## **BaptistCare NSW & ACT, Baulkham Hills NSW, made the following submission on the project:**

### **[SSD 6848 Redevelopment of Lismore Hospital Stage 3B](#)**

DRAWING ELEVATIONS 1

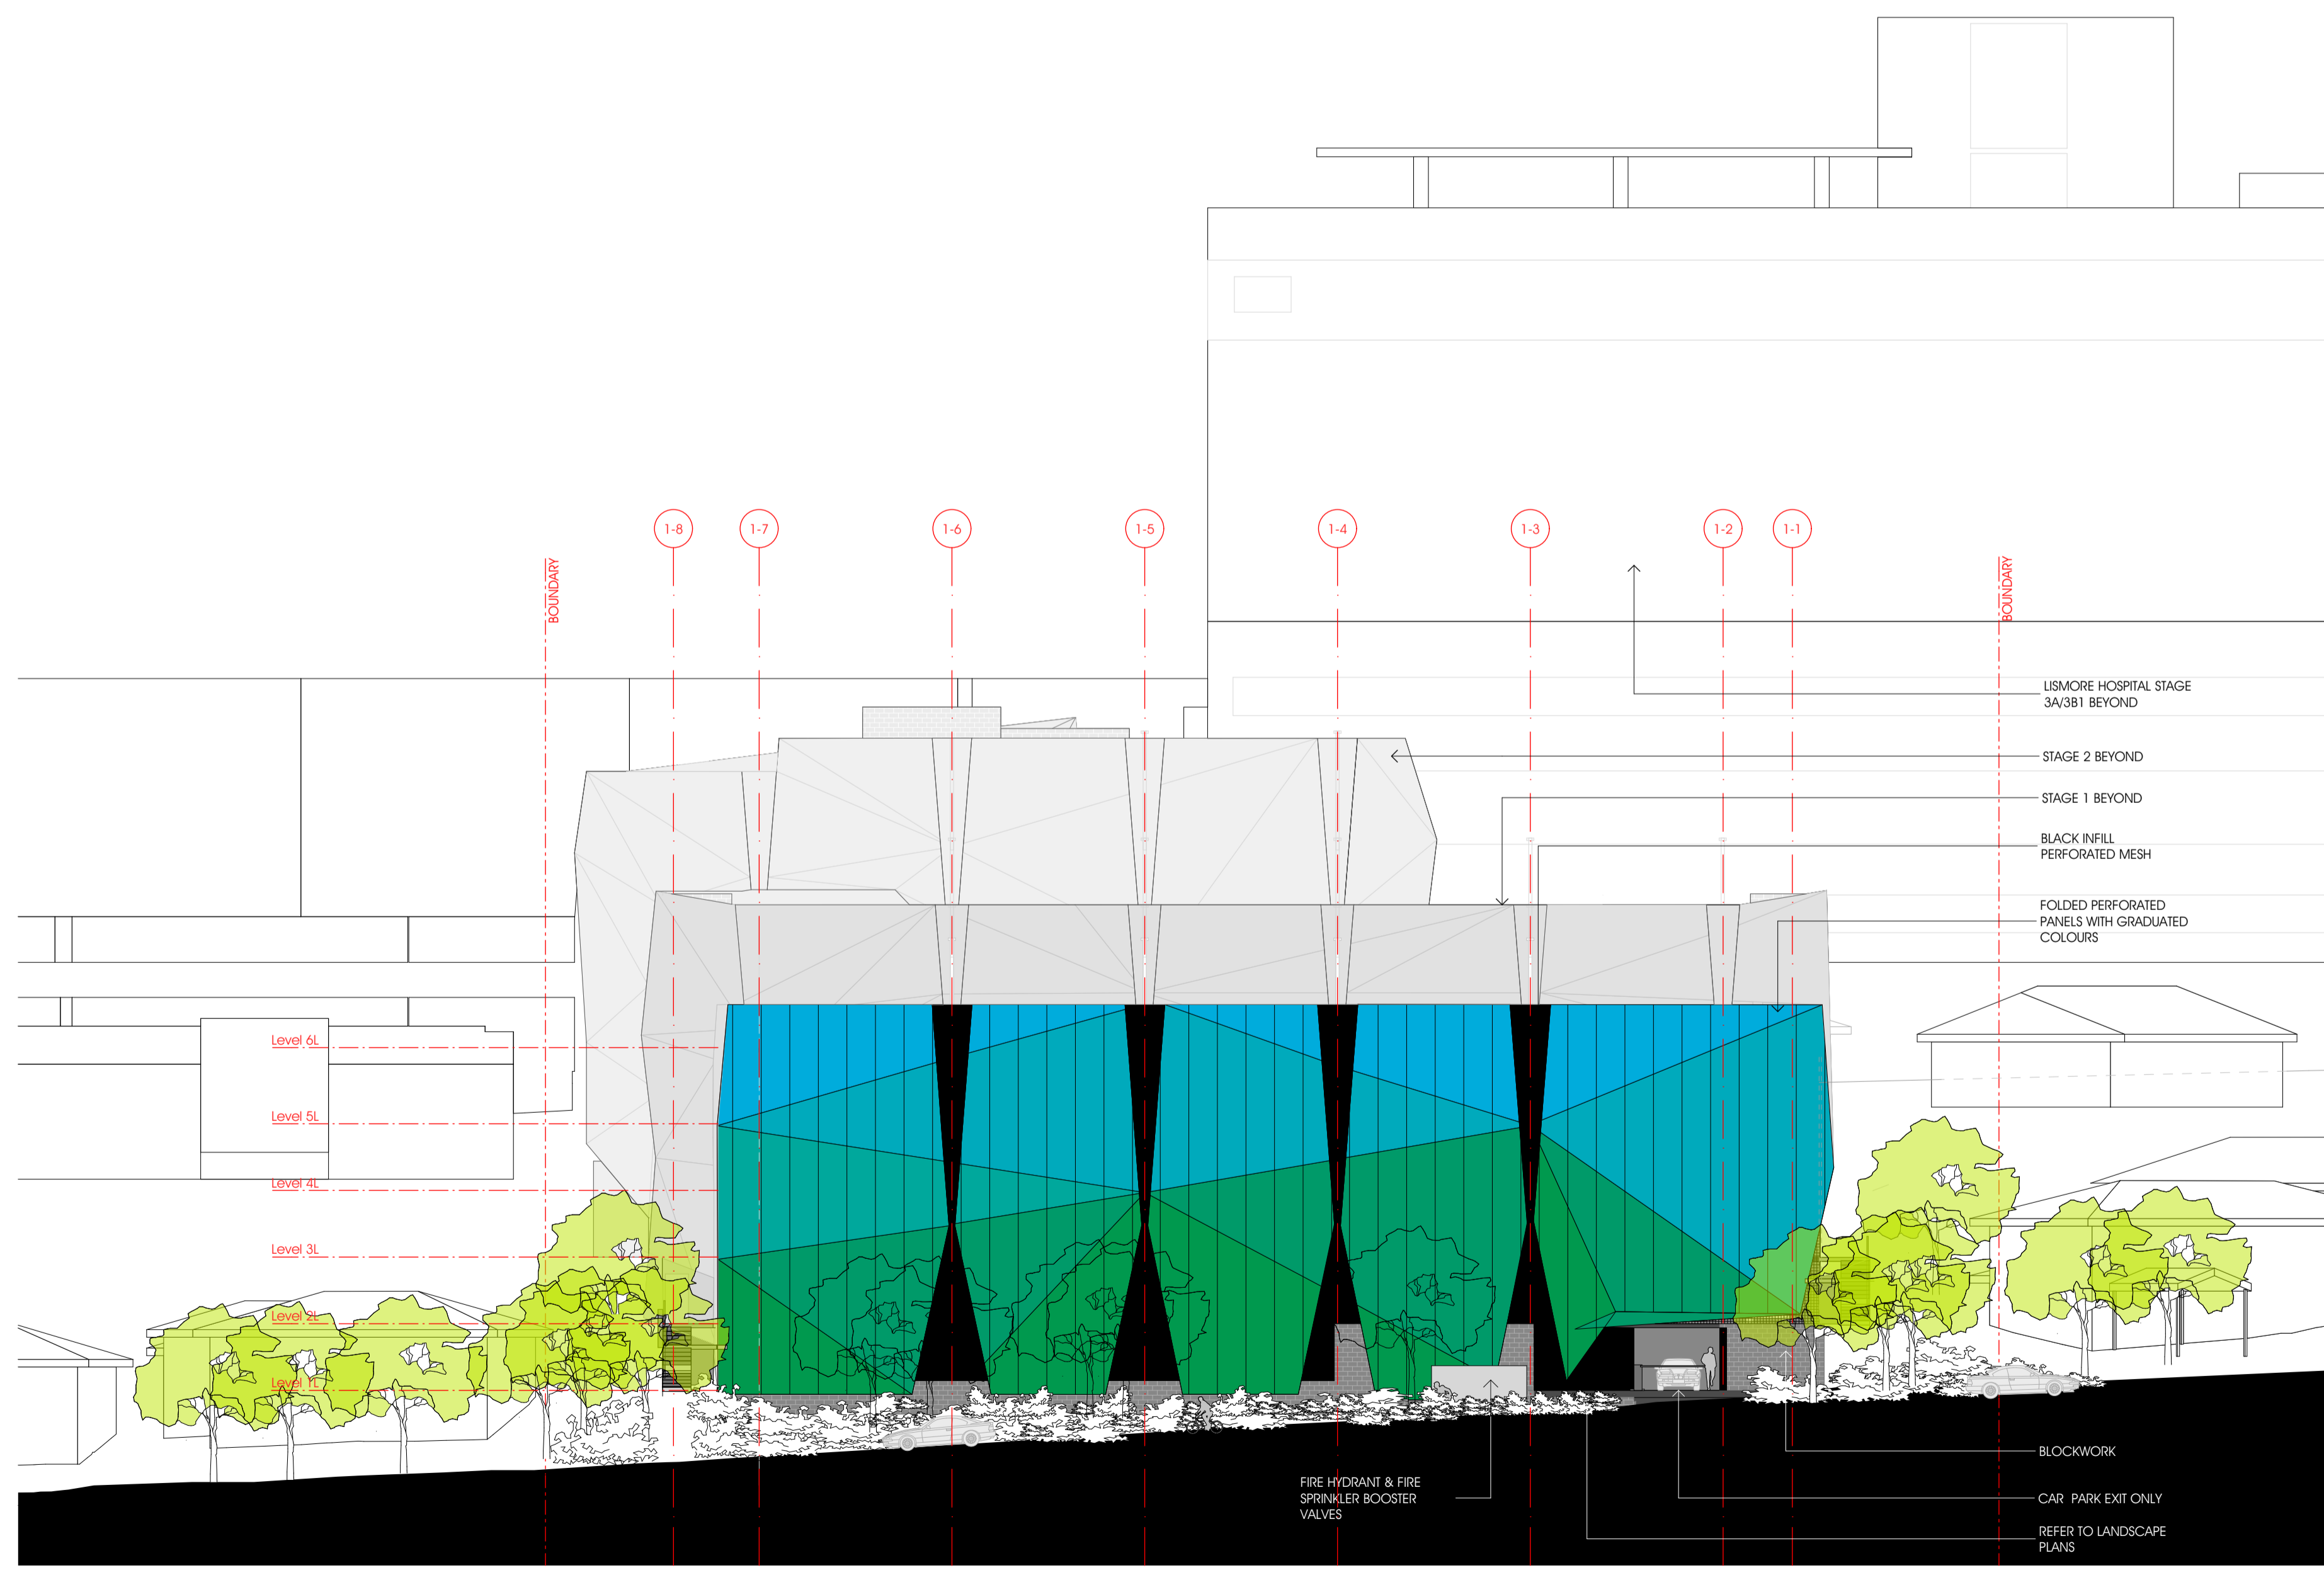
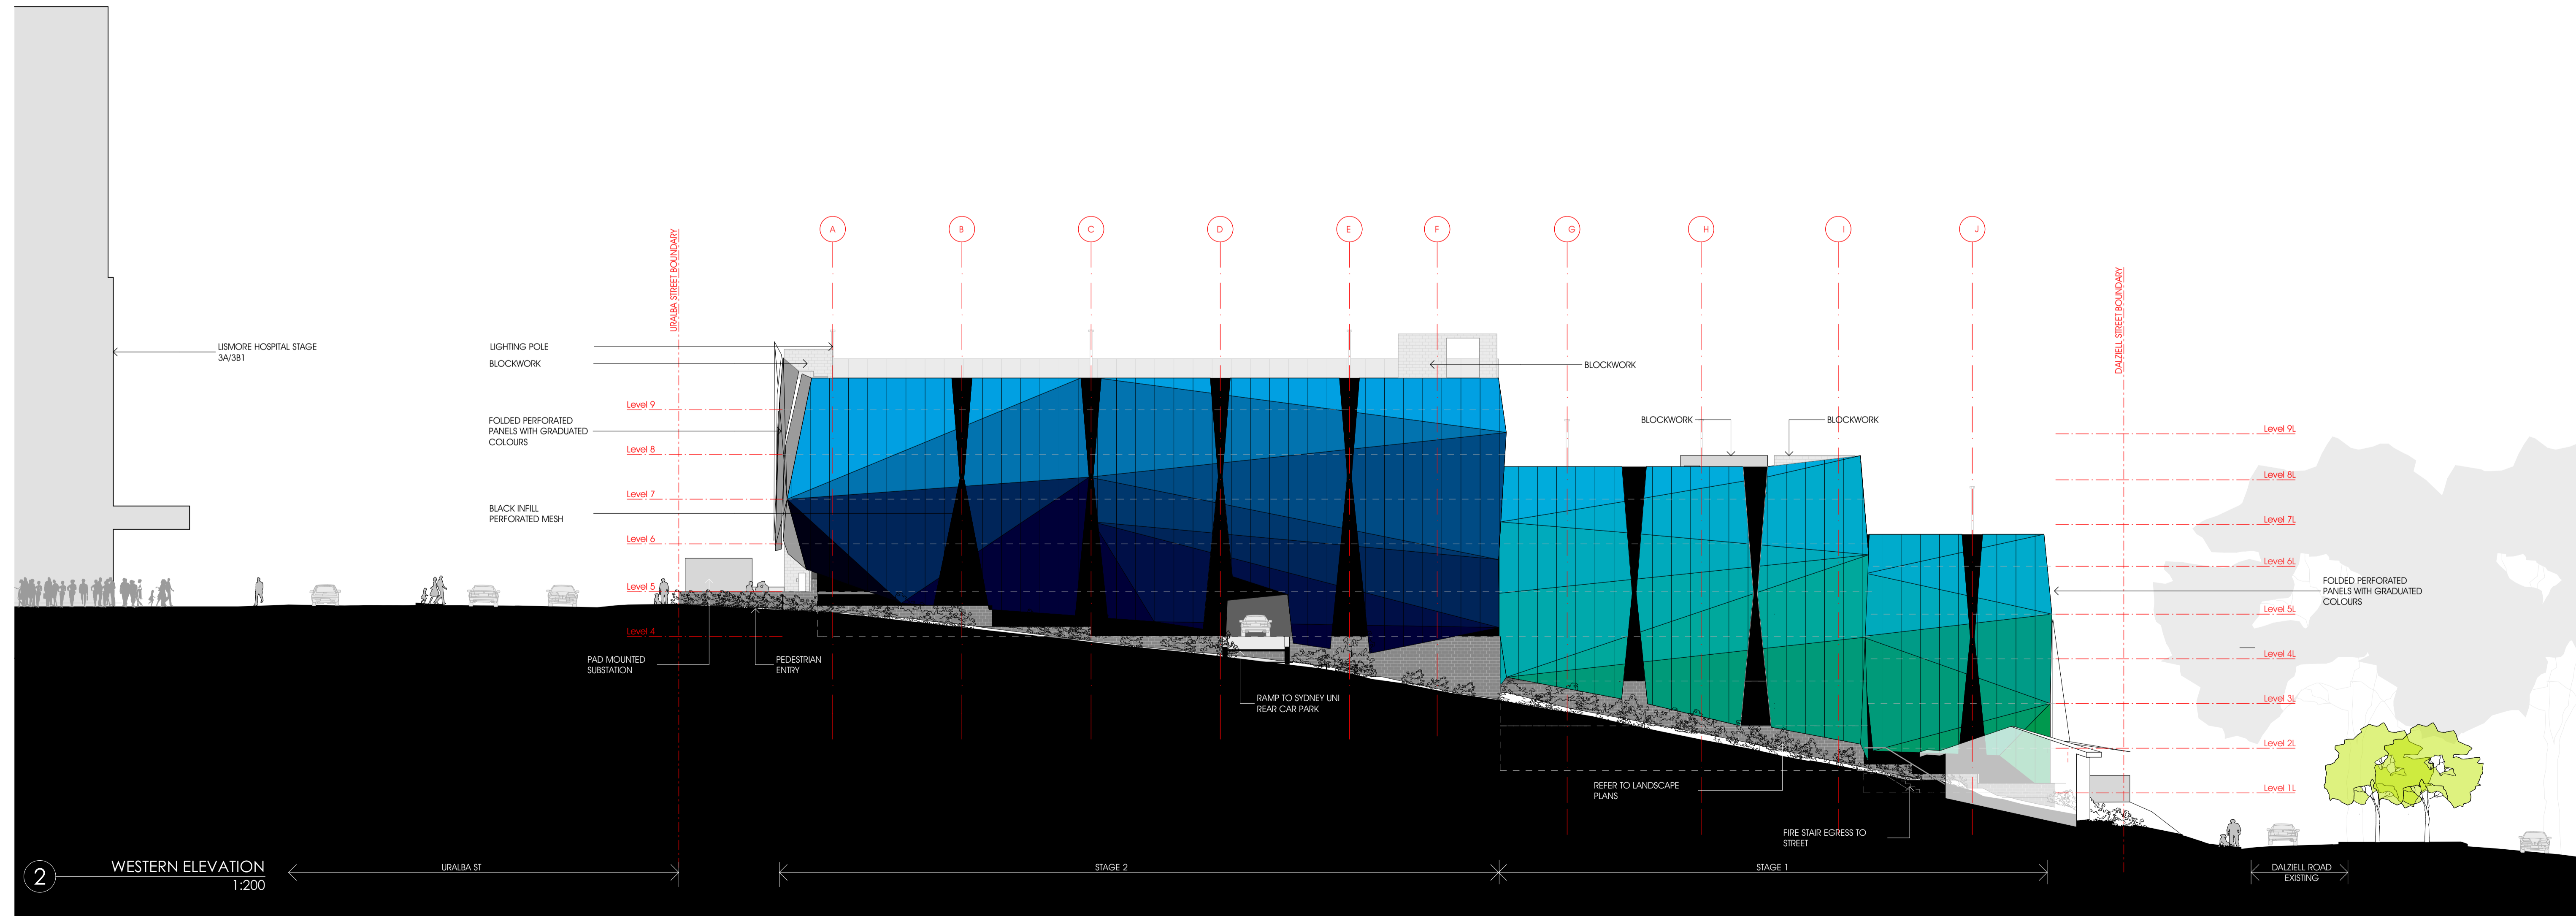
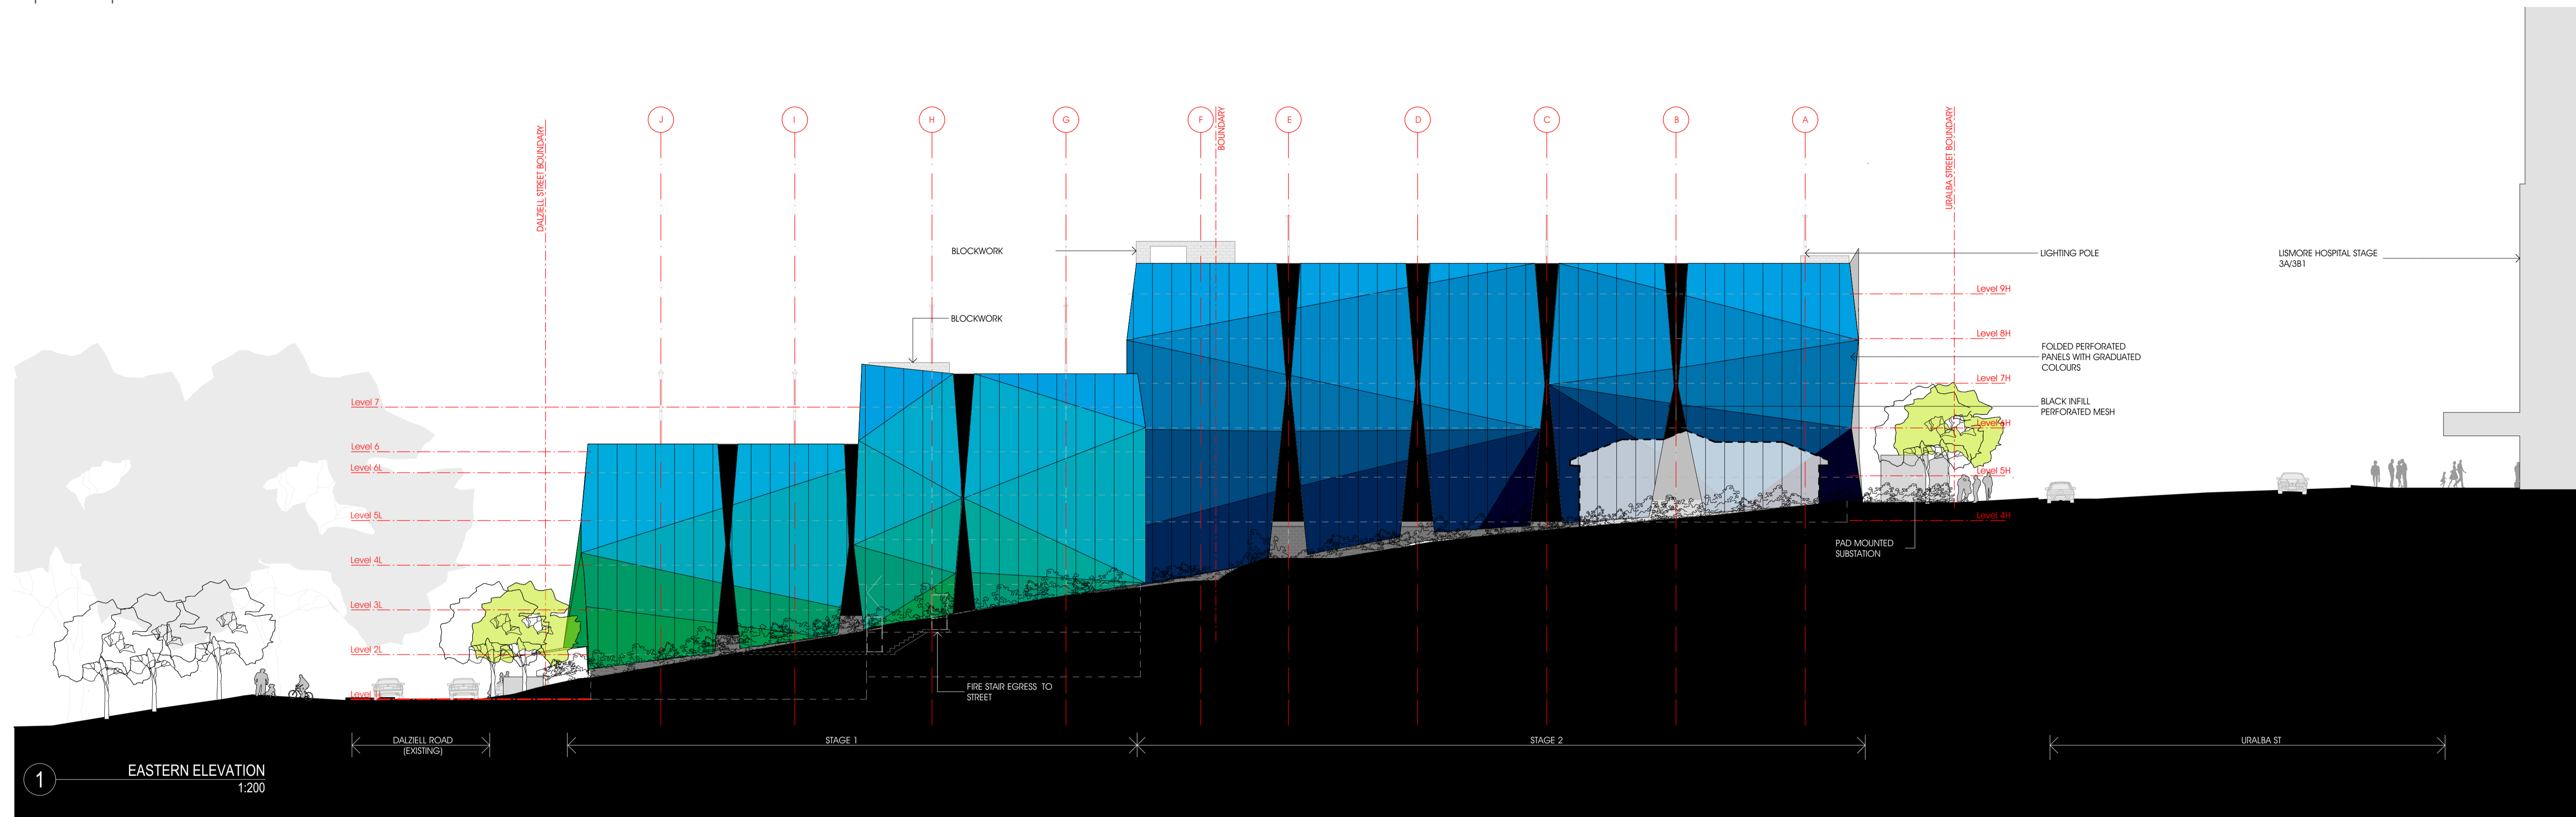
BaptistCare NSW & ACT own and operate a residential village (Illowra Place) on the corner of Dibbs & Dalziell Streets Lismore. We request that landscaping of the open space between our development and the car parking station is given serious consideration. We would like to see the 7 storey car parking station softened with the planting of advanced trees and shrubs in the open space available. This will not only improve the view for our residents it will also provide some acoustic treatment, reducing traffic noise and helping to reduce any air borne pollution as a result of the increased traffic. We have more than 30 aged residents in our Illowra Place and their health and quiet enjoyment of their home is important.
